Subject: Objection to AW-85-18-HH Renewed for avoidance of doubt by the LPA - 31-10-2018

AW-85-18-HH – 10-5-2018 – OBJECTION

OBJECTION TO – AW/85/18/HH, 54 Kingsway – PROPOSALS TO EXTEND HOUSE WITHIN THE SETTING OF CRAIGWEIL HOUSE CONSERVATION AREA.

WHITWORTH AW/85/18/HH NORTH

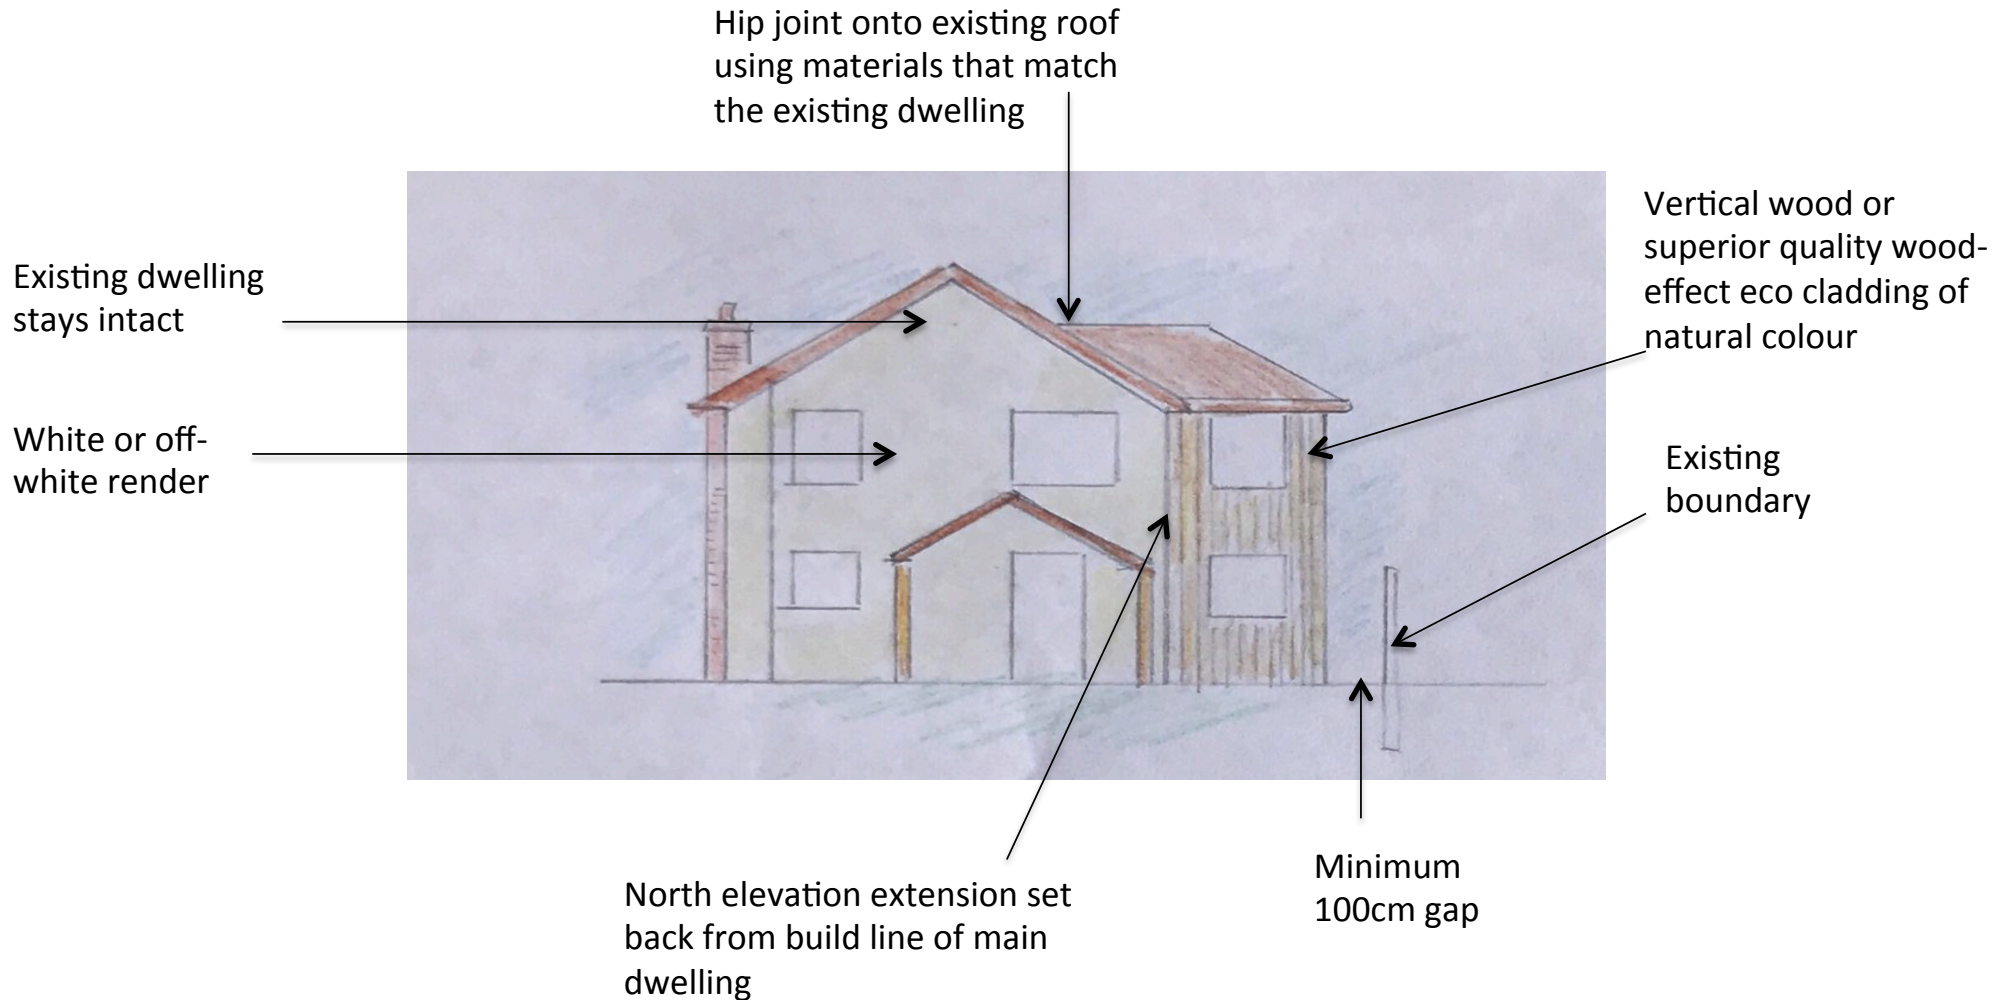
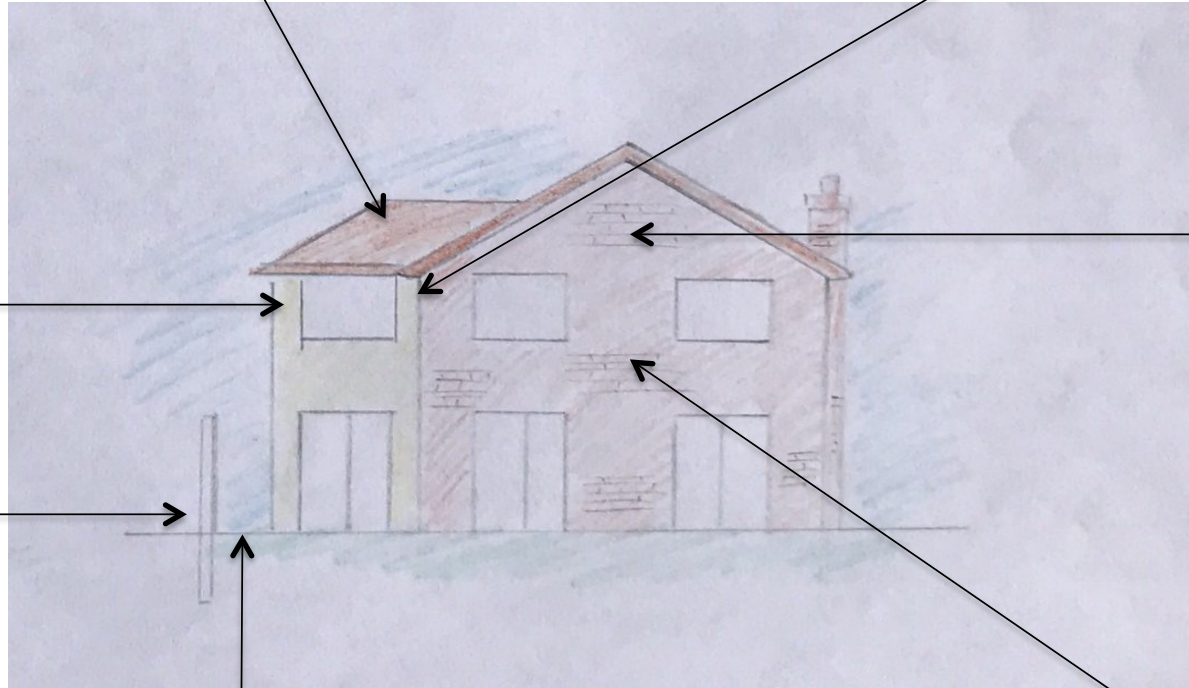
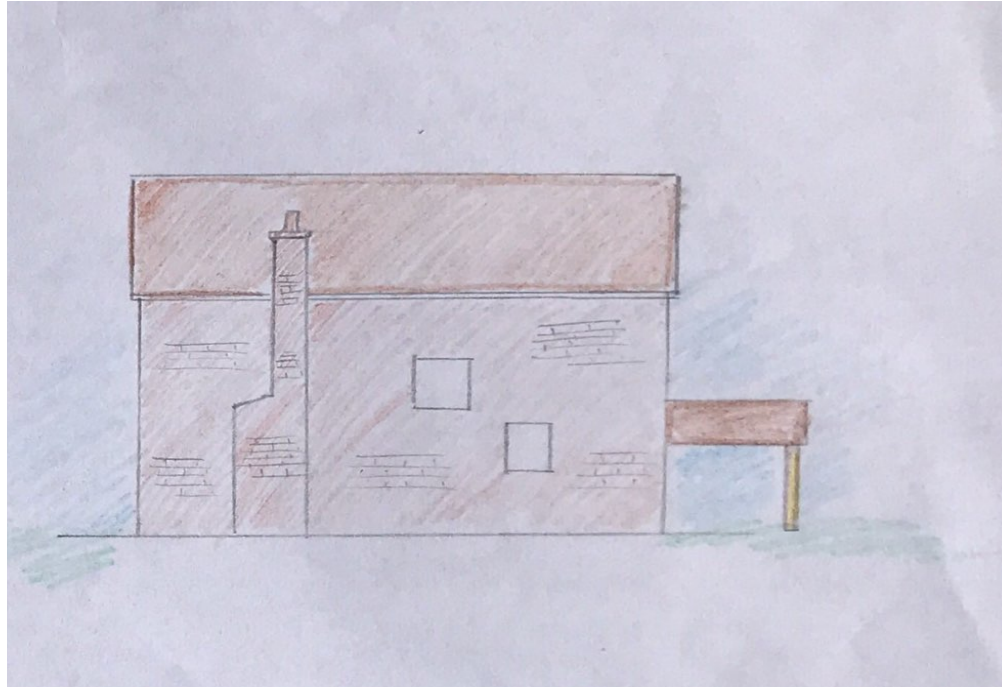
The revised front elevation shows that the space between No. 52 and 54 is highly compromised and 52 will suffer greatly, losing light and having shadows in the garden where they have never existed.

PLEASE NOTE that the garage is to be removed and converted into living accommodation. THE PROPOSED 6 BEDROOM HOUSE NEEDS PARKING SPACE – AND THERE IS NONE. THERE IS NO TURNING AREA OFF ROAD! The applicants park on the road now and it is impossible to get more than one small car parked in the driveway, sticking out onto the drive on the CA and Estate verge.
